FAO: Planning Department,  
Welwyn Hatfield Borough Council

Ref: 6/2023/2244/LB  
Date: 03/01/2024

## HISTORIC BUILDINGS AND CONSERVATION ADVICE

**RE: *Northaw House Coopers Lane Northaw Potters Bar EN6 4NG***

Proposed Joinery Details

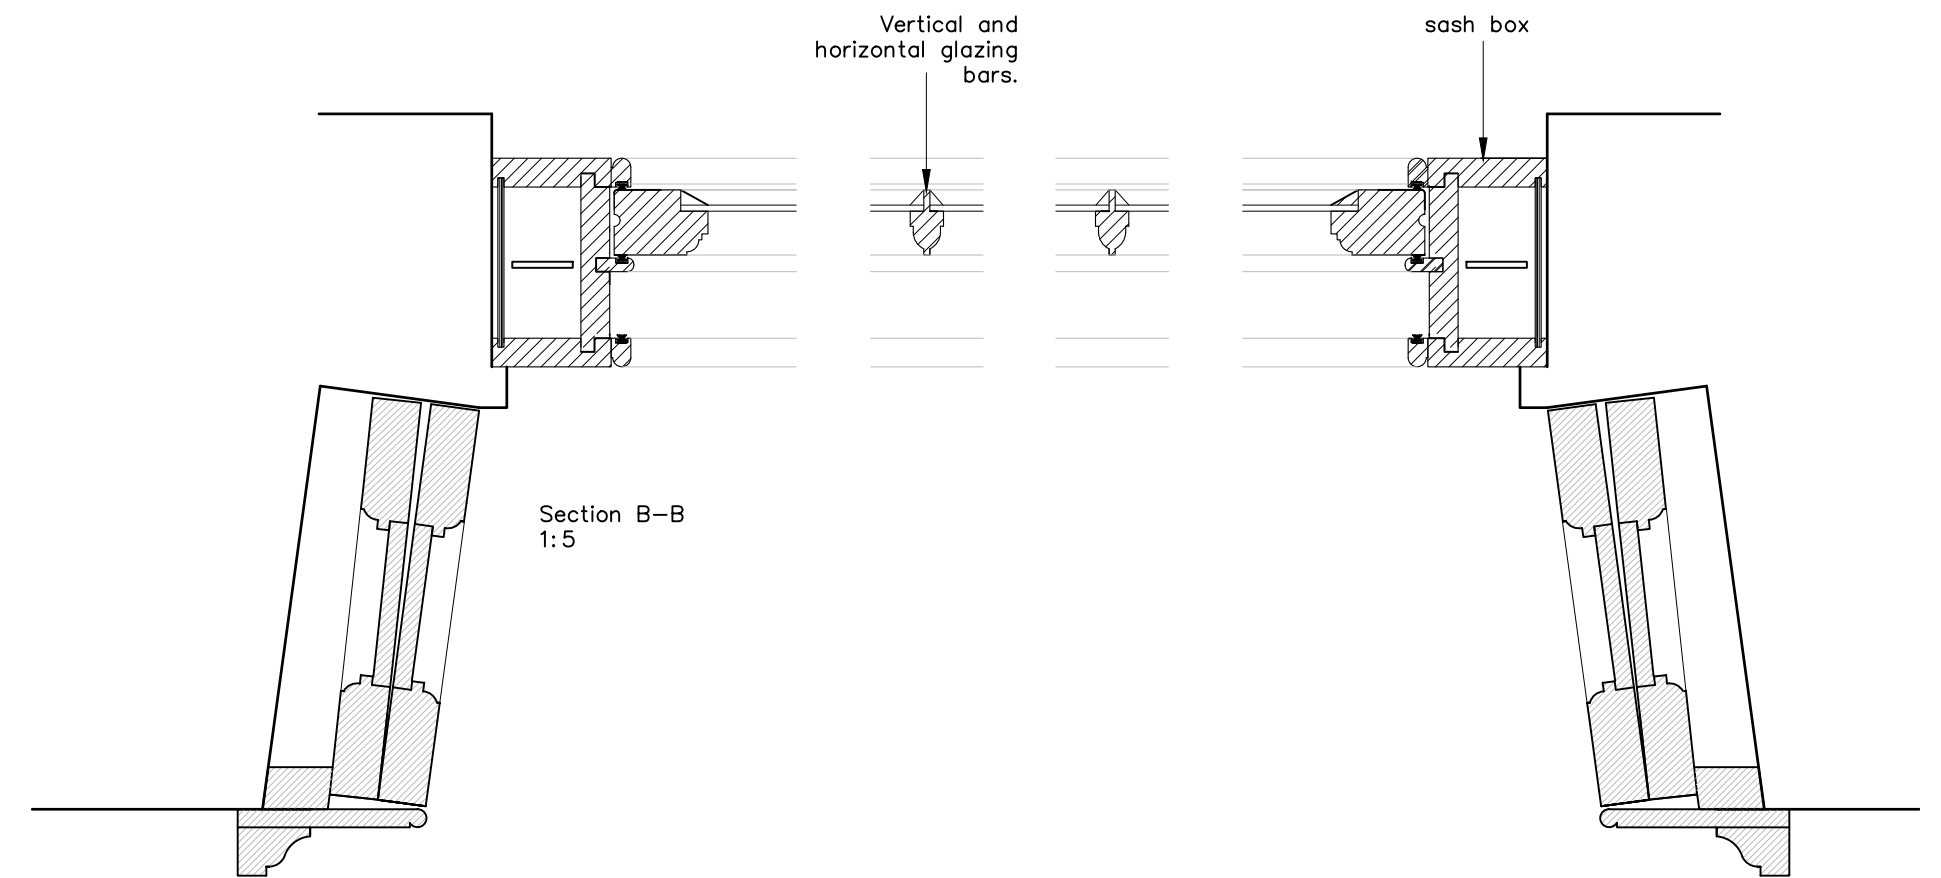
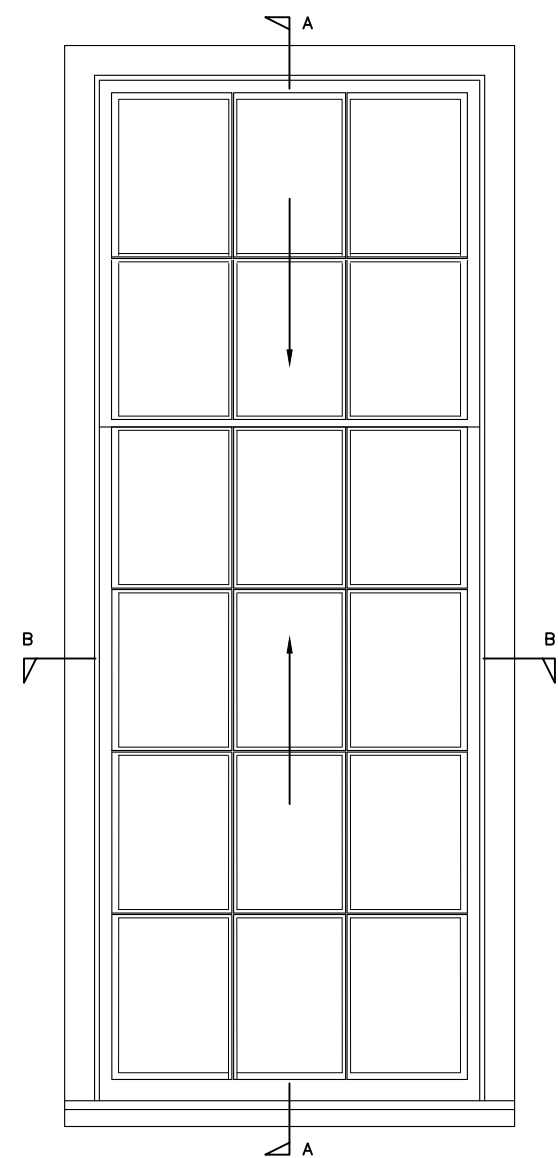
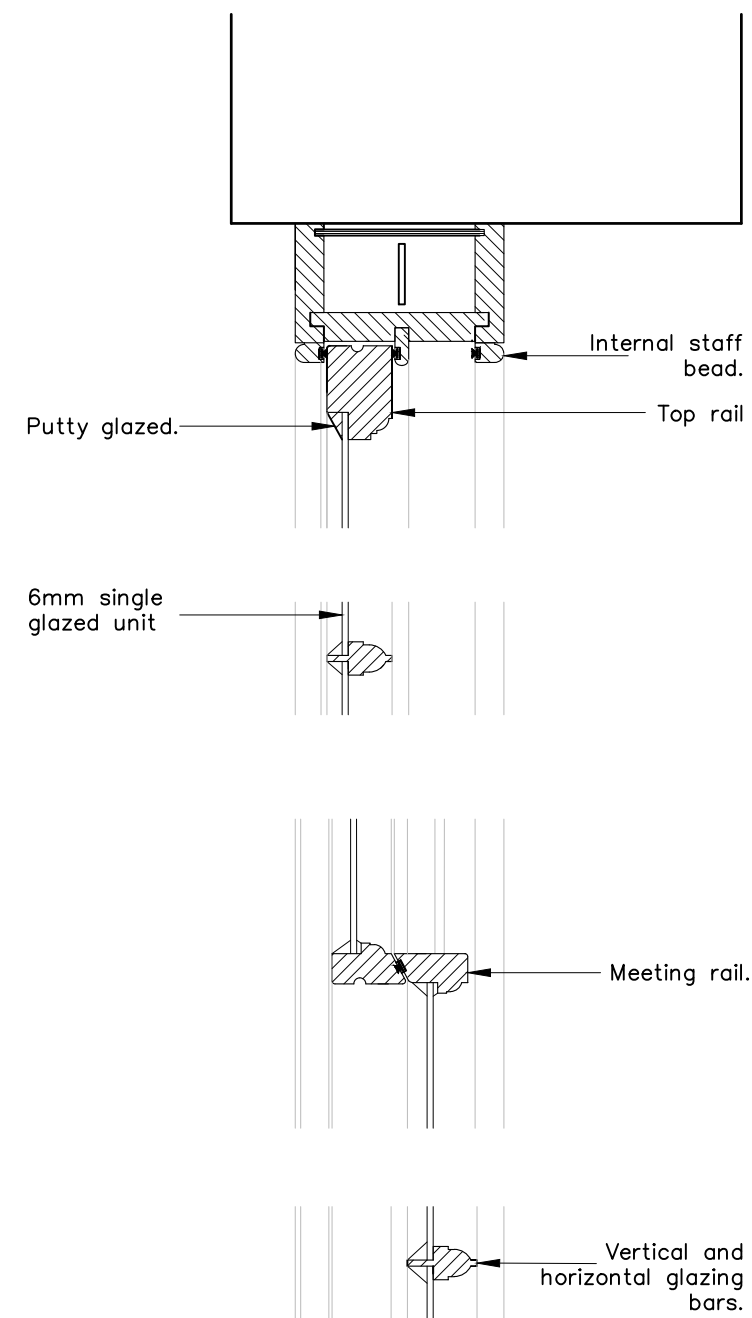
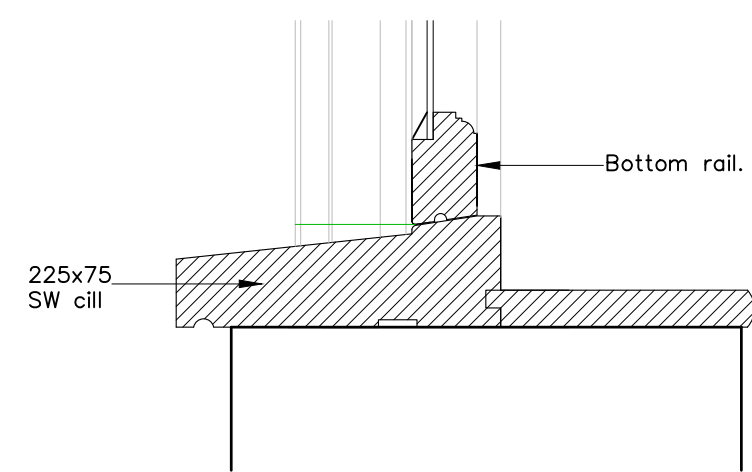
This application is for the replacement of 6 ground floor windows within the northern elevation of Northaw House.

Removing the existing windows at ground floor and replacing them with sash windows would create a false arrangement. Whilst there may have been sash windows at some point, it is clear from the evidence shown in the images in the Heritage Statement, that this was before the eighteenth or early nineteenth century extensions and alterations. The sash windows on the northern elevation may have never existed alongside the subsequent eighteenth/ early nineteenth century extensions; reinstating an earlier window design would create a potentially inaccurate composition that never existed. This would detract from the architectural and archaeological interest of the listed building.

retained where possible, if they are beyond economical repair then they should be replaced with accurate copies. The proposal would result in the complete loss of windows which are considered to be positive, and the replacement windows would not be accurate copies. This would detract from the architectural and archaeological significance of the listed building.

1. The proposal lacks sufficient information to support the proposed replacement windows;
2. Notwithstanding point 1, the proposal would potentially create an inaccurate composition that never existed, lacking authenticity and integrity. This would adversely affect the architectural and archaeological interest of the listed building; and
3. The proposal fails to follow best practice guidance on the repair and upgrading of traditional windows as set out by Historic England.

Taking the above into consideration, even if the existing windows do not date from the early nineteenth century and are later replacements, they accurately follow the pattern and design of those seen in the 1805 engraving, therefore making a positive contribution to the significance of the listed building. Following best practice guidance set out above, the windows should be repaired and
